19th April 2021

Re: Proposed Non-Material Amendment (pursuant to Section 96A of the Town and Country Planning Act 1990) to Planning Permission CM/16/18/PL

This application seeks to make the following amendments to the planning permission through a change to the approved plans and drawings listed within condition 2 as well as an amendment to the wording of condition 6:

05 Site Key Plan
1 : 1250

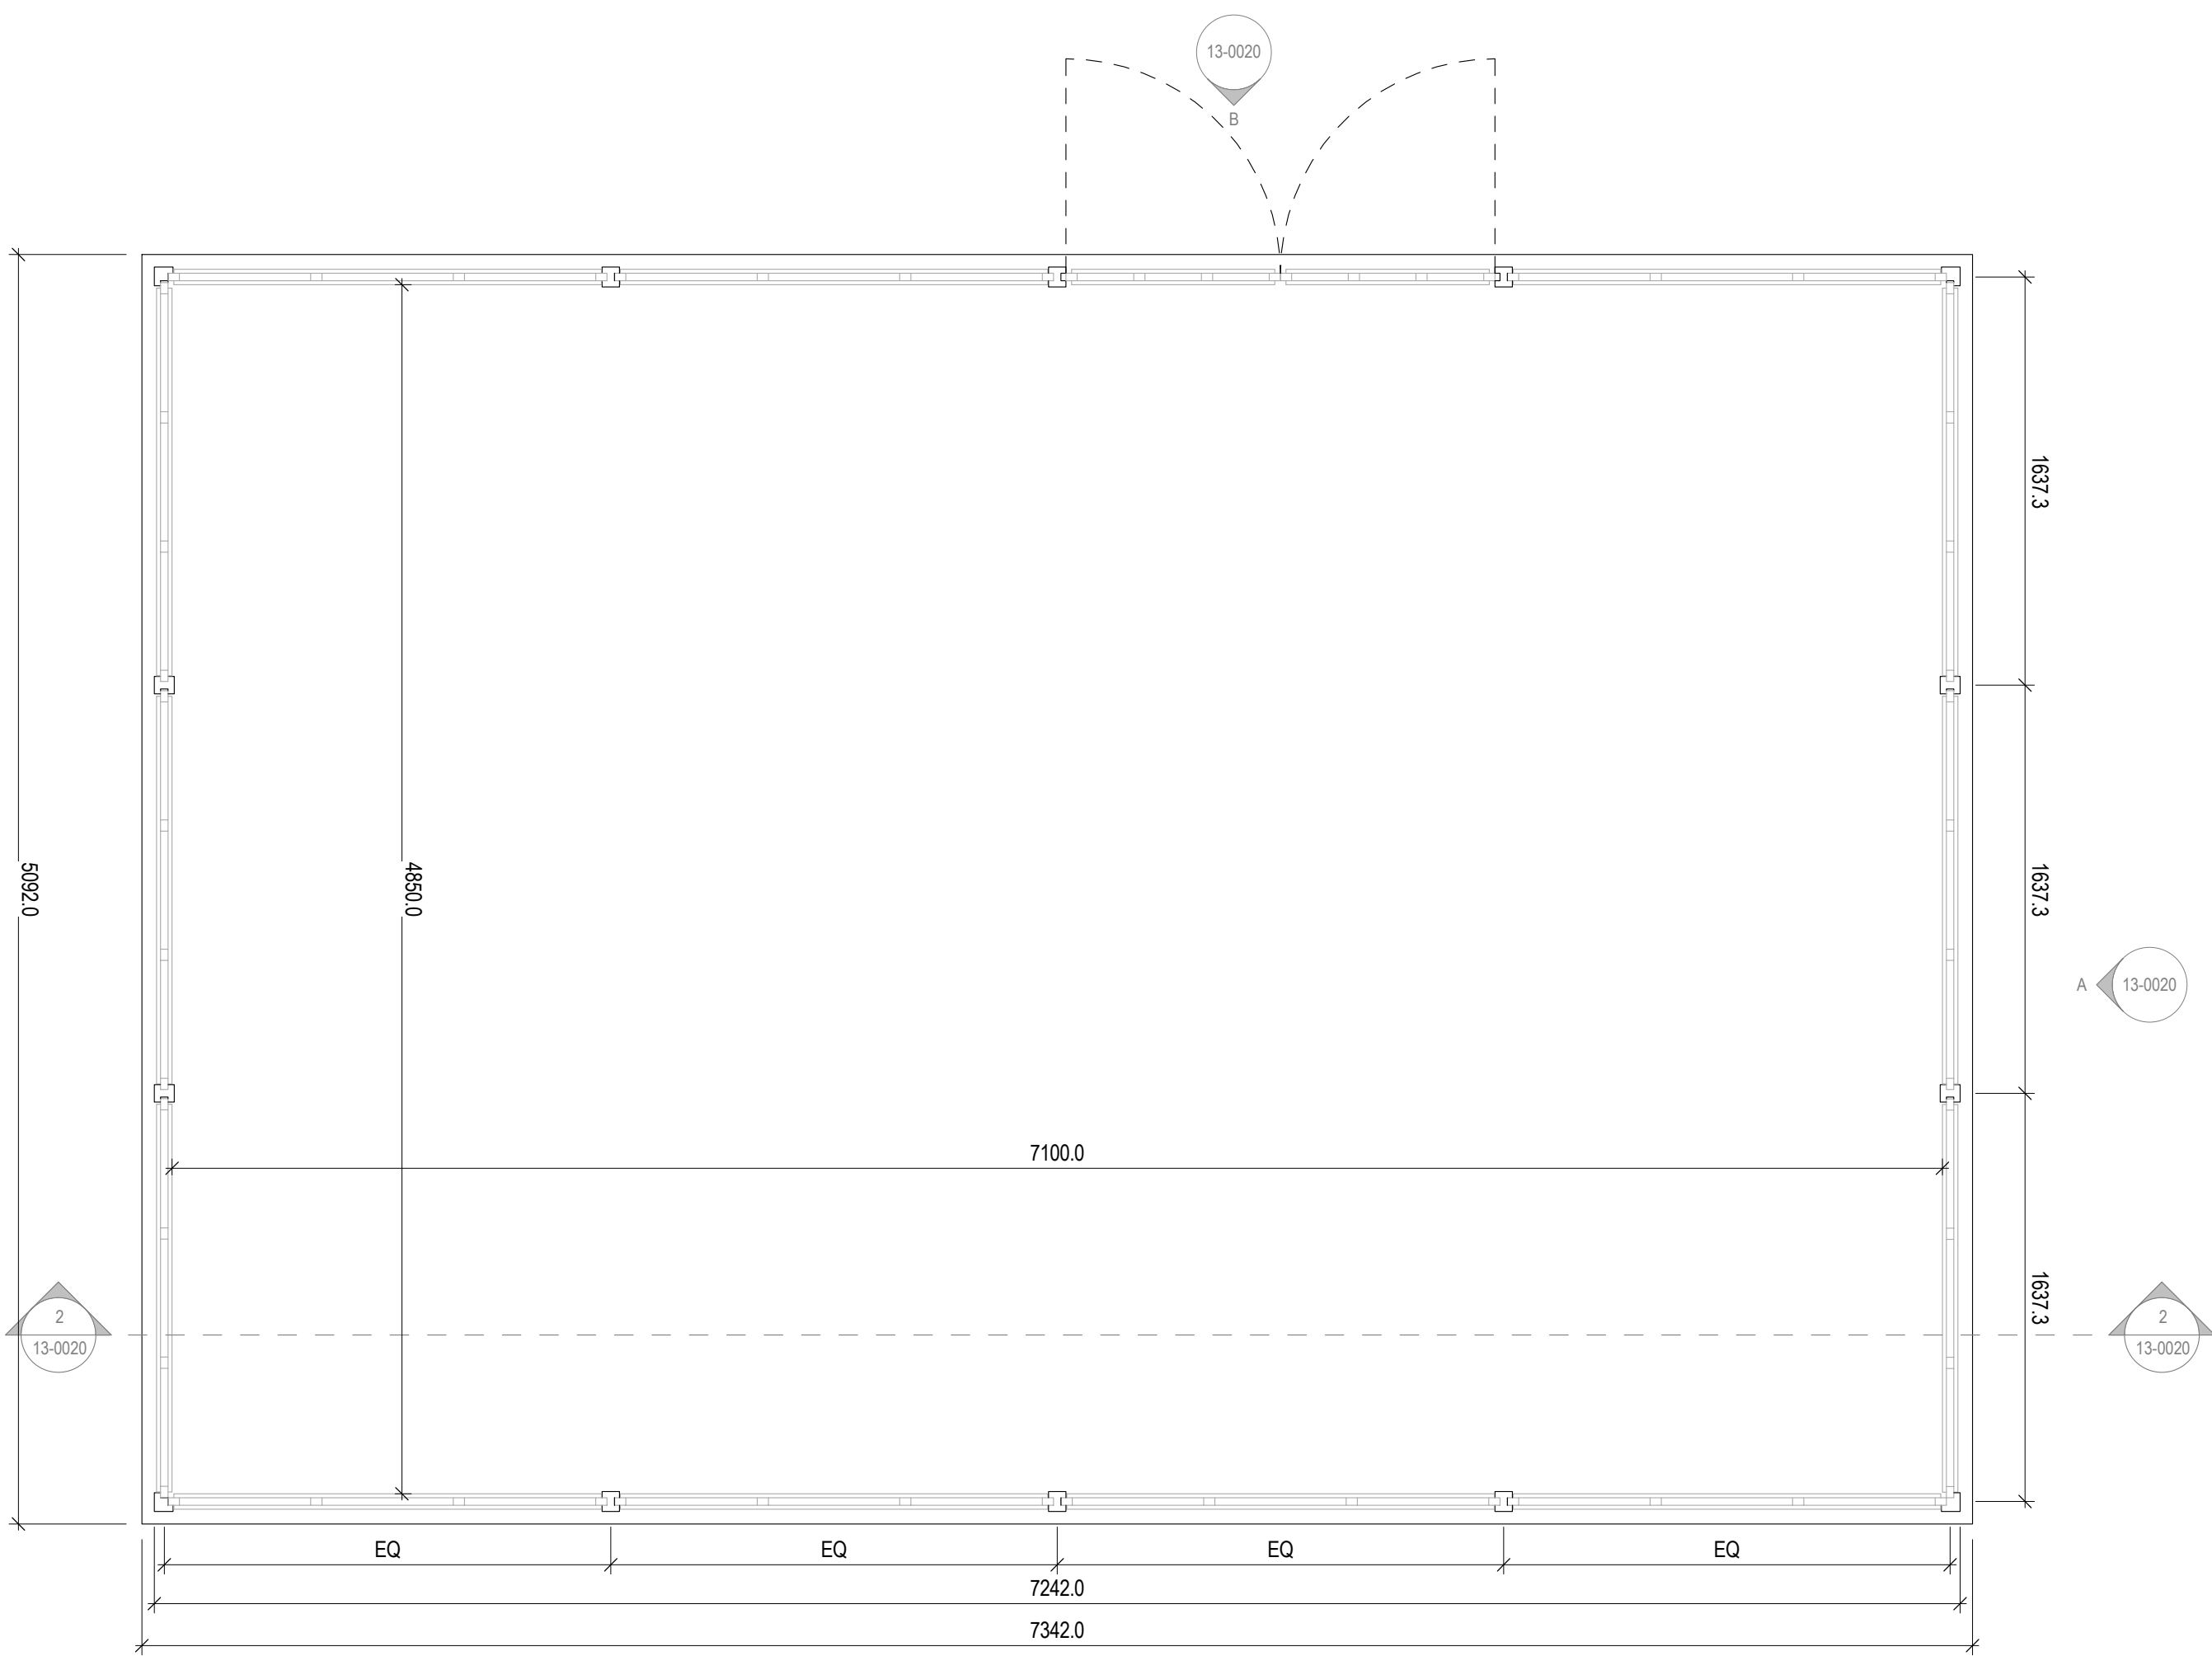
3. The introduction of air source heat pumps (within an associated enclosure) together with a new electricity substation on the site. In developing the detailed construction specification for the new care home for the operator, an objective throughout has been to reduce the development's carbon footprint. An 'all electric' design with roof mounted photo-voltaic panels is therefore proposed which would reduce the CO2 generated by the development by 40% and obviate the need for connection to the gas network. In order to achieve the 'all electric' design, generate hot water and maximise the benefit of the free electricity provided by the photo-voltaic panels, air source heat pumps are required on the site and which are proposed to be located in a secure external plant enclosure constructed of timber hit and miss fencing.

drawing title:
M9316- HUN- 02- SL- DR- A- 13-0022

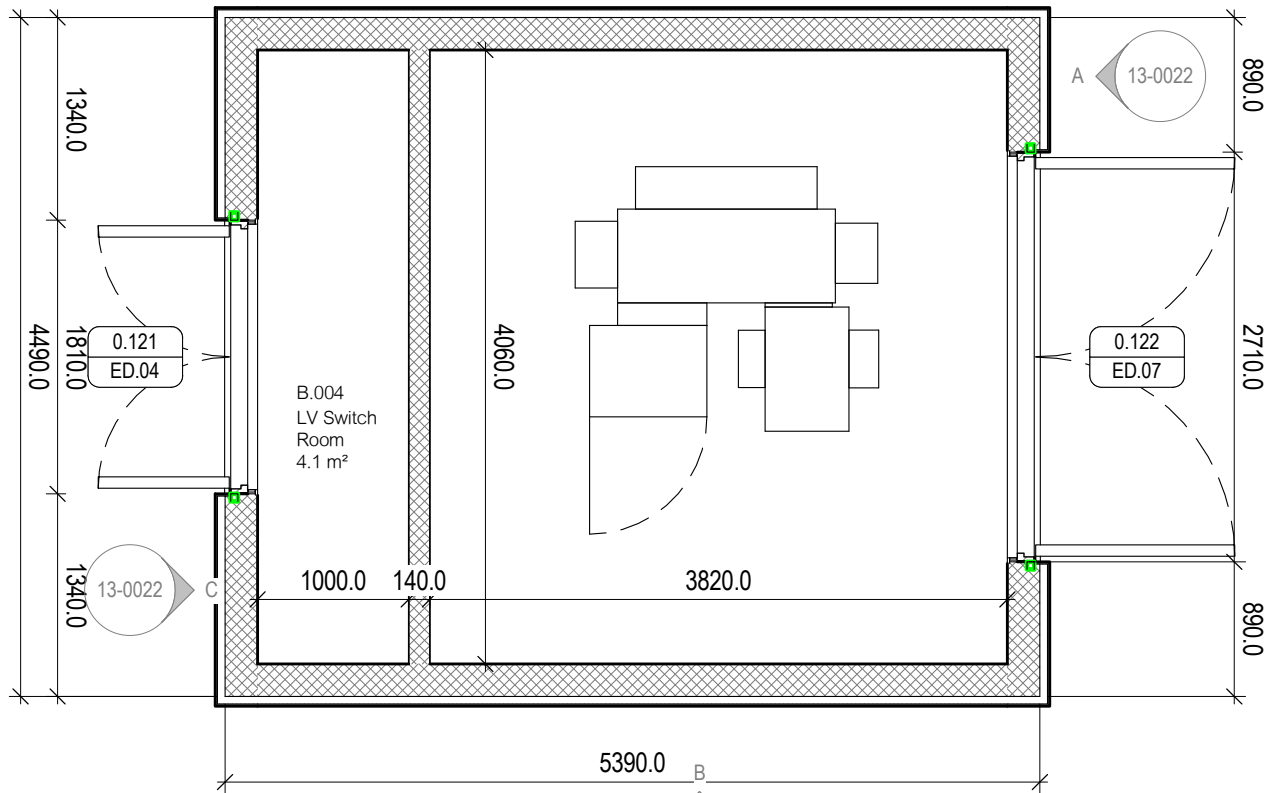
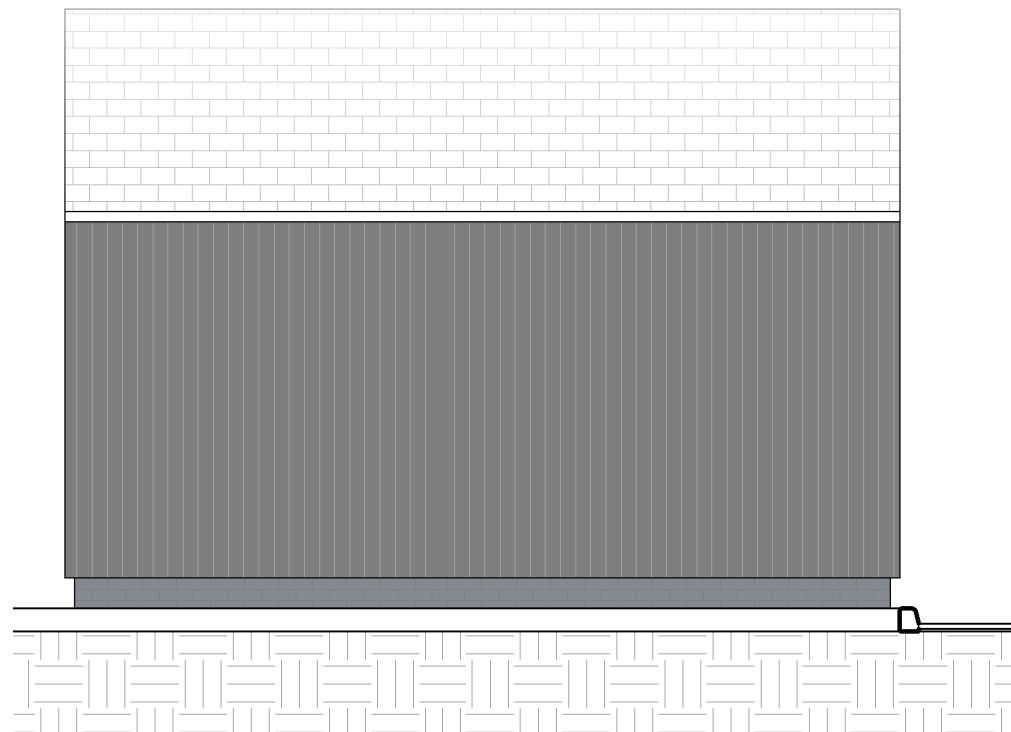
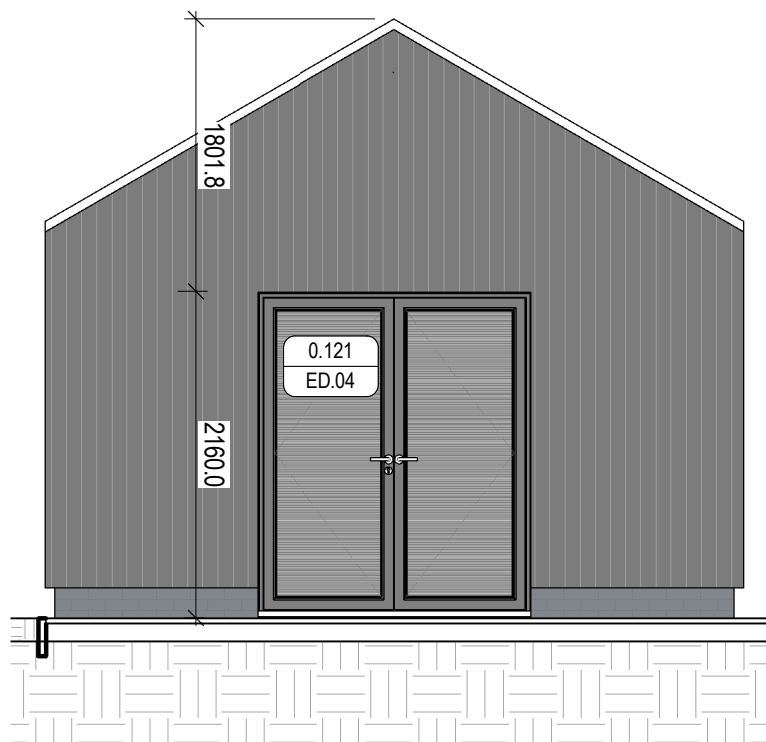
In order to provide the 500kVa maximum demand that this will require we have been advised by the District Network Operator - Scottish & Southern Electricity Networks - that a new substation will be required on the site and this is shown in the proposed amendments to the approved plans and drawings. The substation building is proposed to be constructed out of external materials that match that of the care home building – namely Wienerberger Pagus Grey facing brickwork, Blackened Charred Accoya timber cladding and grey Winchcombe roof tiles.
